Sent: 01 September 2020 11:03
To: Zac Denton <Zac.Denton@arun.gov.uk>
Subject: RE: A/108/20/CLP - Request for further information

Subject: A/108/20/CLP - Request for further information

Project	5 BADGERS WALK, ANGMERING		
	Proposed single storey rear extension		
Client	Mr & Mrs Vincent		
Drawing no.	AM/BW/04	Date	June 2020
Scale	AS SHOWN		
Drawn By	WG

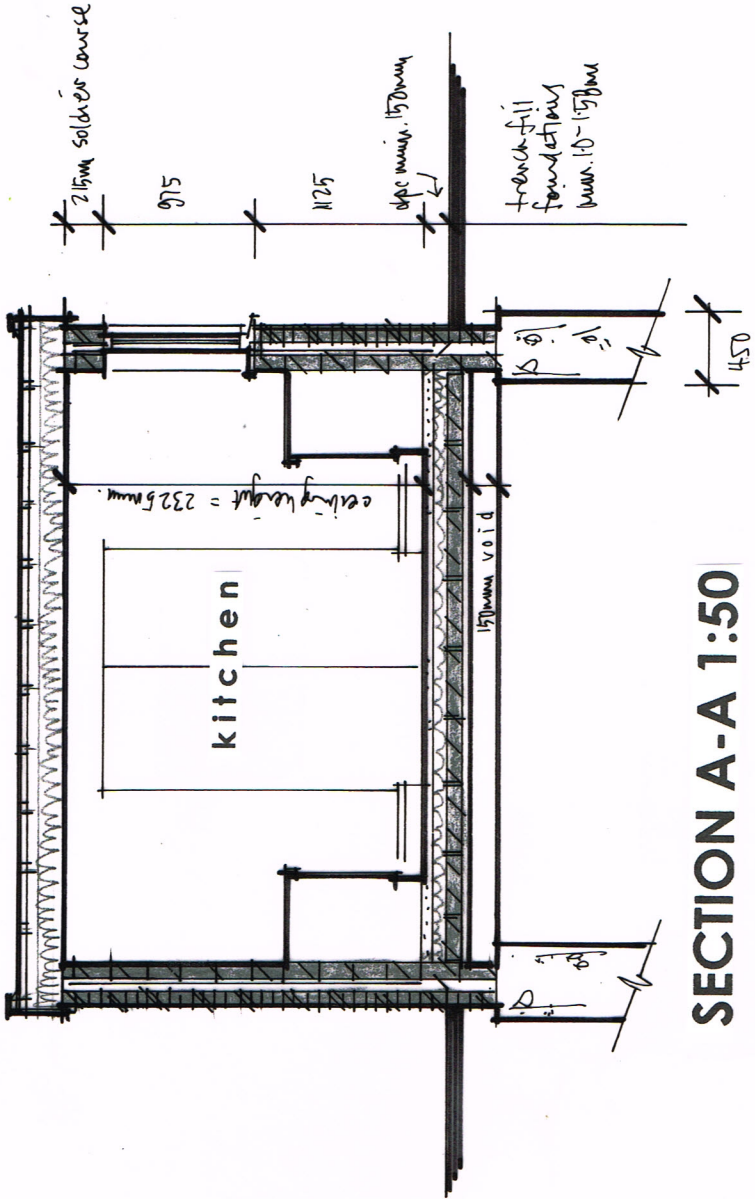
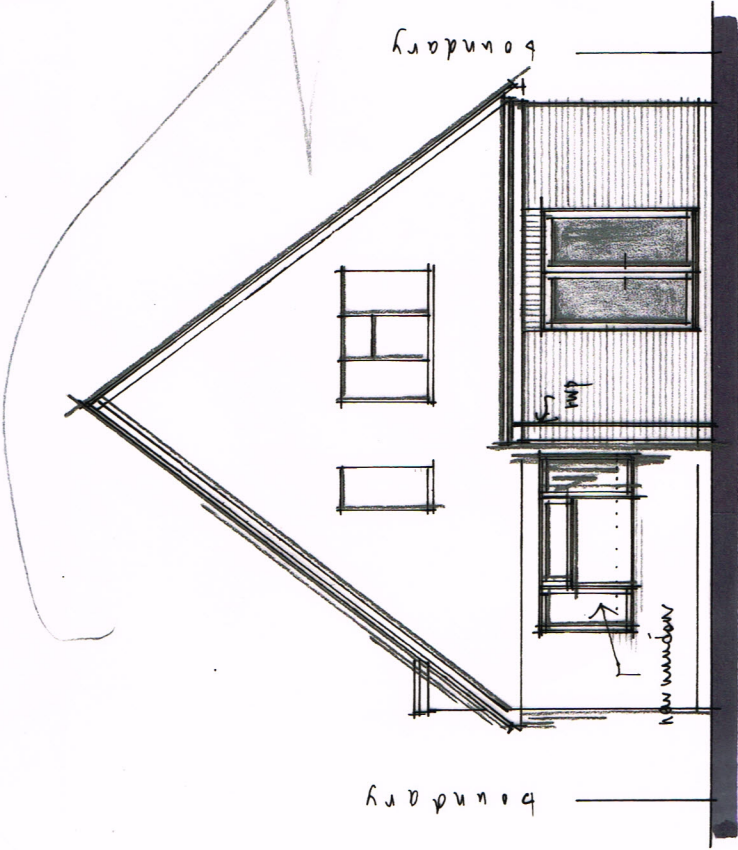
Are you able to confirm the proposed materials of the proposal?

Hi Zac,
Materials will be of similar appearance to the existing dwelling as per drg no AM/BC/04.
Walls – brick
Flat roof – felt/composite GRP
Windows – white pvcu.
Regards.
Wayne
